# Rezoning Transportation Analysis

Petition Number: 2020-105

**From:** Lakisha Hull  
[Lakisha.Hull@ci.charlotte.nc.us](mailto:Lakisha.Hull@ci.charlotte.nc.us)  
704-432-5492

Date	Description
08-19-20	First Review

RZ-1.0

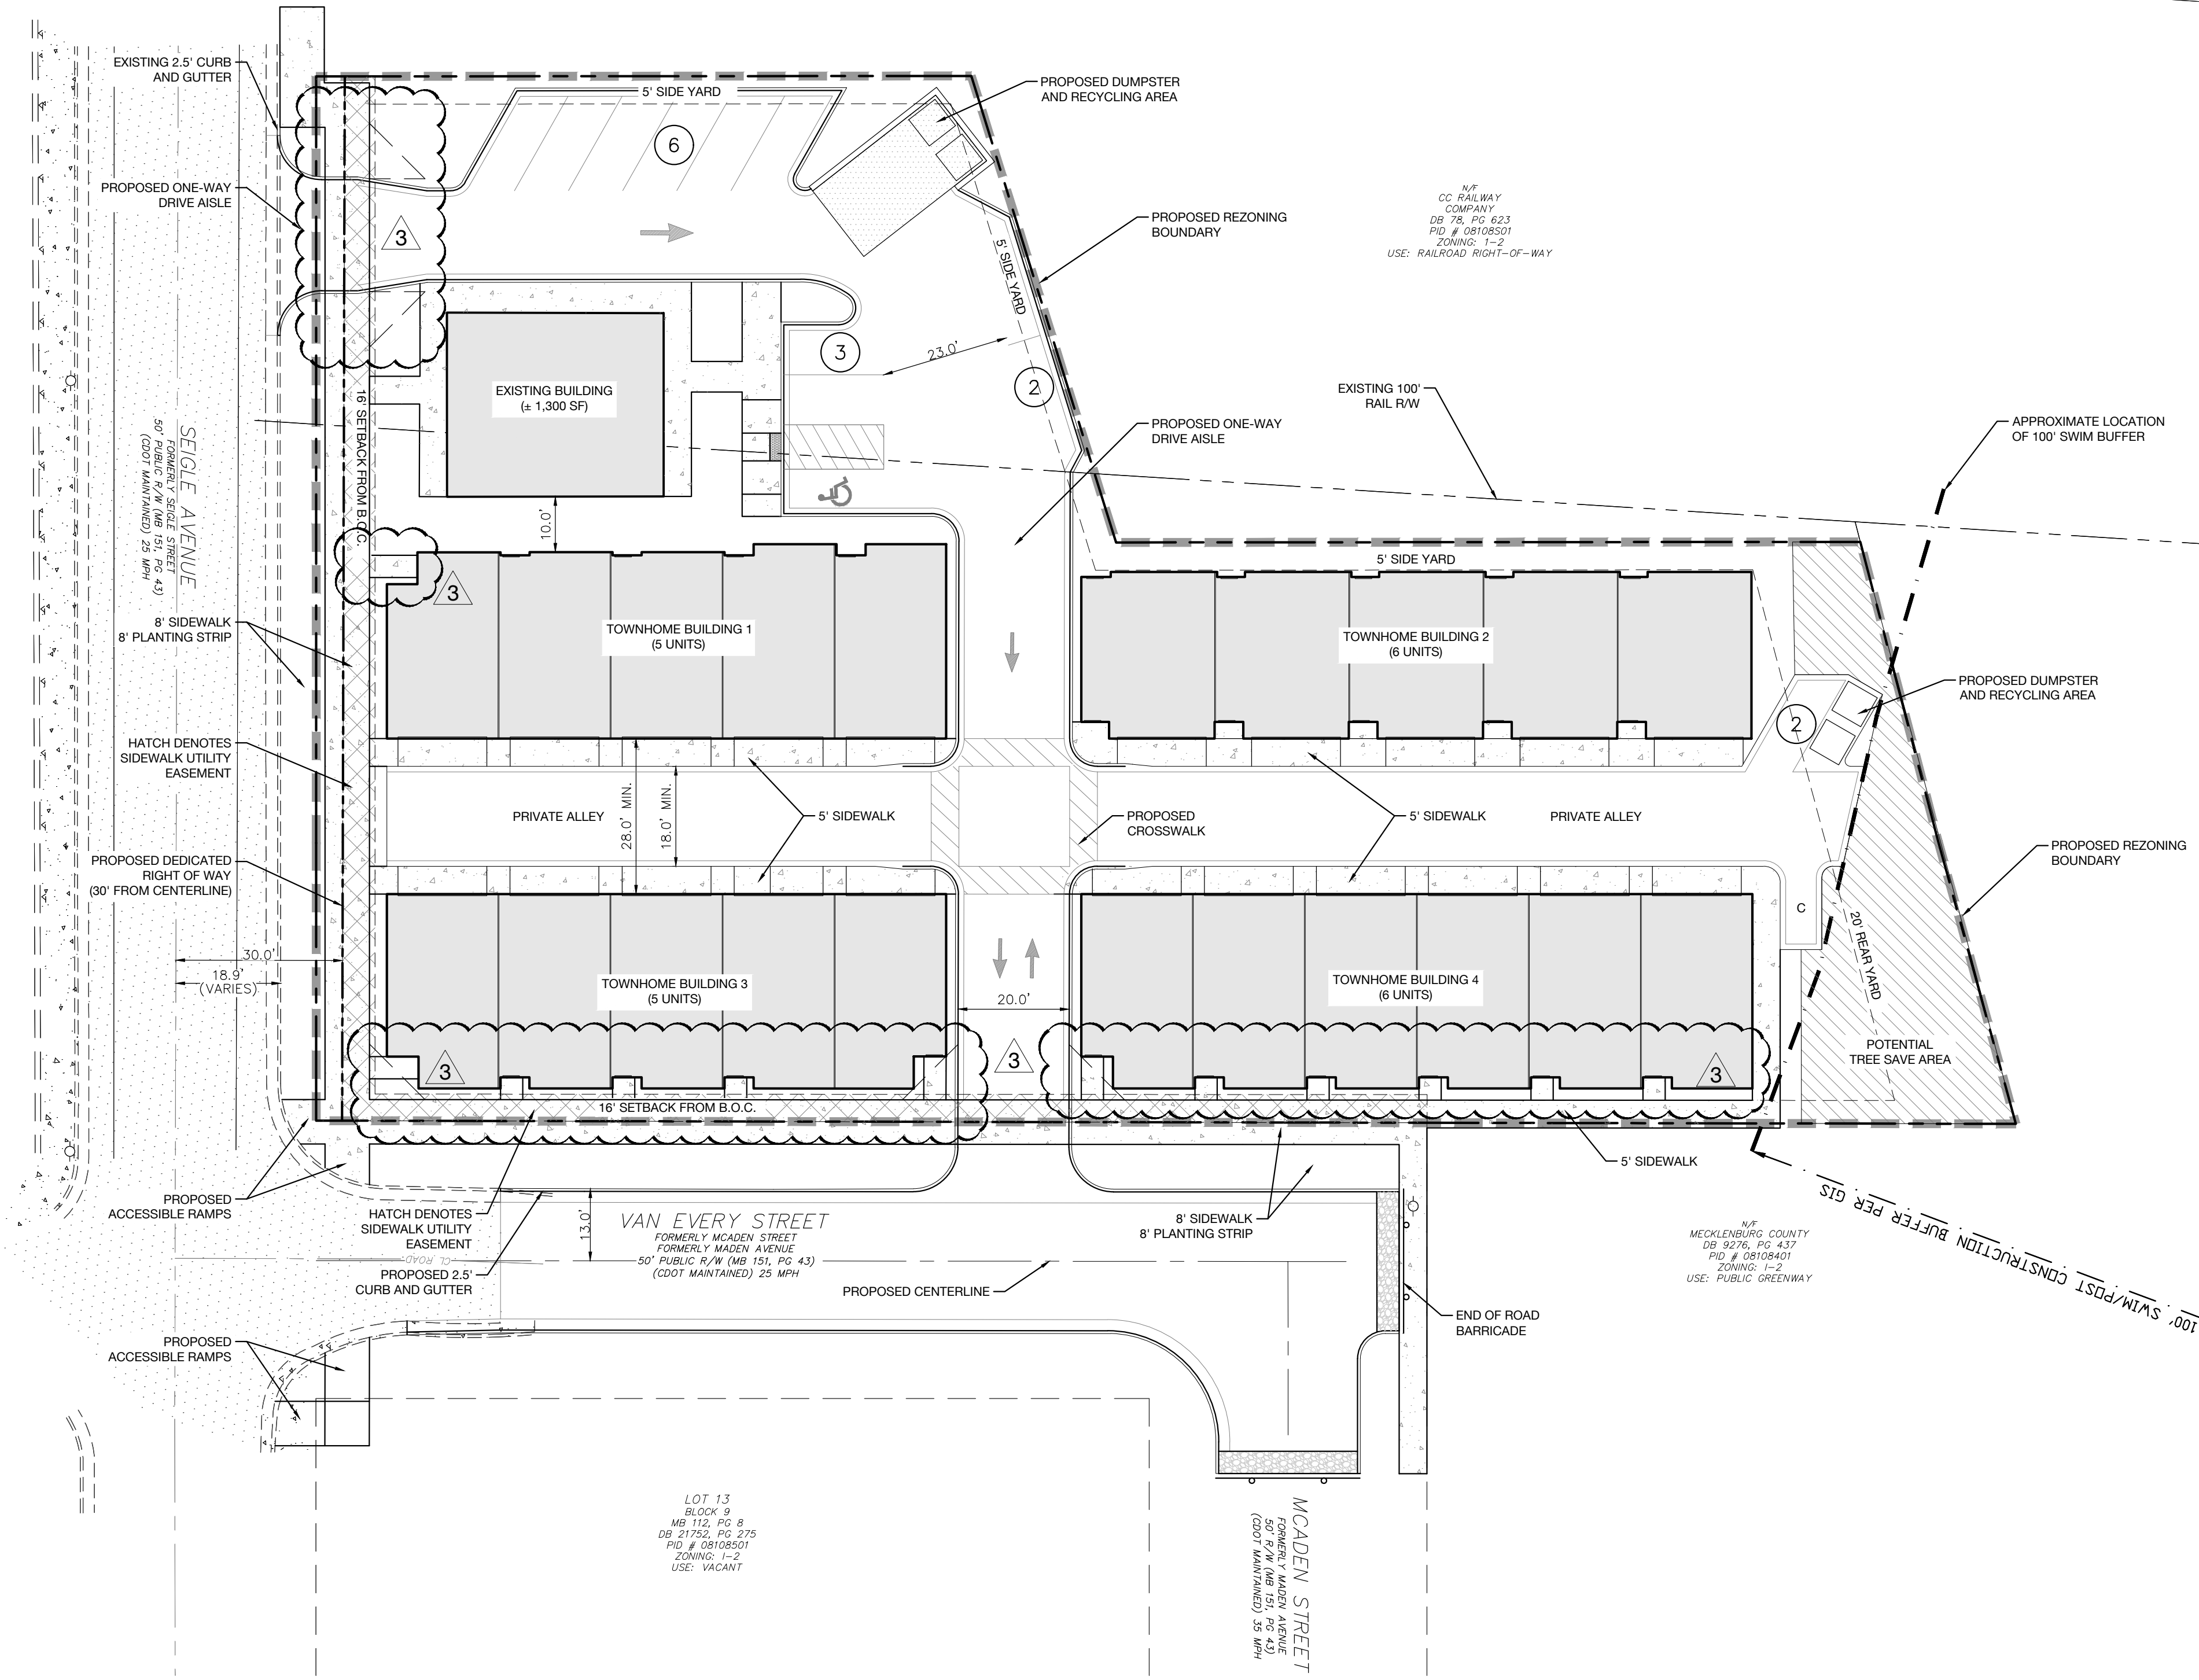
The site plan should show the curb and gutter labeled and dimensioned from the centerline for each road.

5. The petitioner should revise the site plan and conditional note(s) to reconstruct two curb ramps on the north quadrant of the Seigle Avenue/Van Every Street Intersection in accordance with PROWAG and the ADA law.

6. The petitioner should revise the site plan and conditional note(s) to provide Intersection Sight Distance at all public access driveways per Charlotte Sight Distance Policy.
7. The petitioner should revise the site plan to add a note specifying dedication and fee simple conveyance of all rights of way to the City before the site's first building certificate of occupancy is issued. CDOT requests right of way set at 2' behind back of sidewalk where feasible.
8. The petitioner should revise the site plan to add a note specifying all transportation improvements will be approved and constructed before the site's first building certificate of occupancy is issued. The petitioner may phase transportation improvements if said improvements and phasing are explicitly described in site plan notes.
9. ~~Resolved-Sample format for comment that is resolved~~
